# CITY OF ALBUQUERQUE

March 5, 2018

**RE: Eagle Ranch MVD-Retail (Phase 1: MVD Building)  
Eagle Ranch Rd (Tract C, Cottonwood Pointe)  
Request for Certificate of Occupancy – Permanent  
Hydrology Final Inspection - Disapproved  
Engineer's Stamp Date 8/22/17 (B13D002C)  
Certification Dated: 3/1/18**

TYPICAL POND SECTION G
NTS
C-3.0

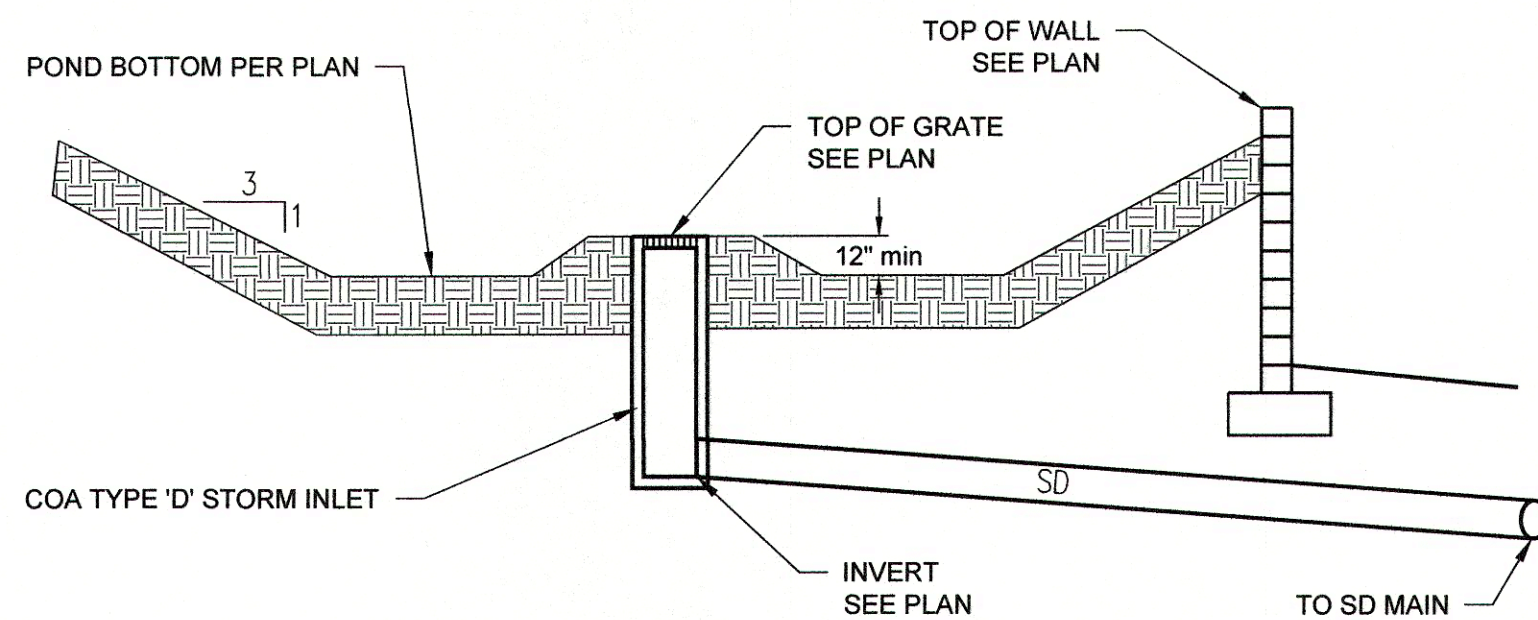
1. First Flush Pond "B" needs to be deepened to 12" below top of grate in order to provide first flush ponding, per detail G, C-3.0:

OVERFLOW SPILLWAY H
NTS
NOT BUILT
C-3.0

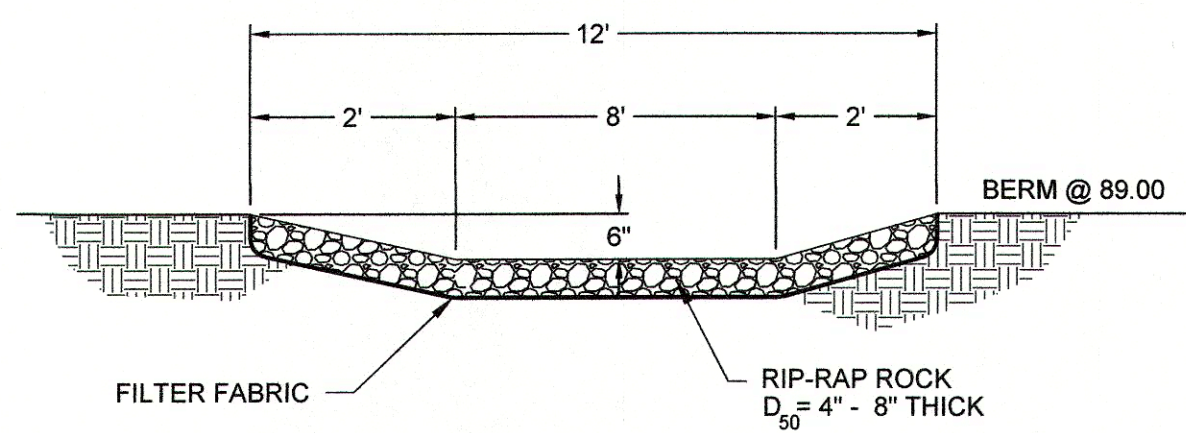
2. The rock for the emergency spillway needs to be replaced with d50=4" rock, per detail H, C-3.0:
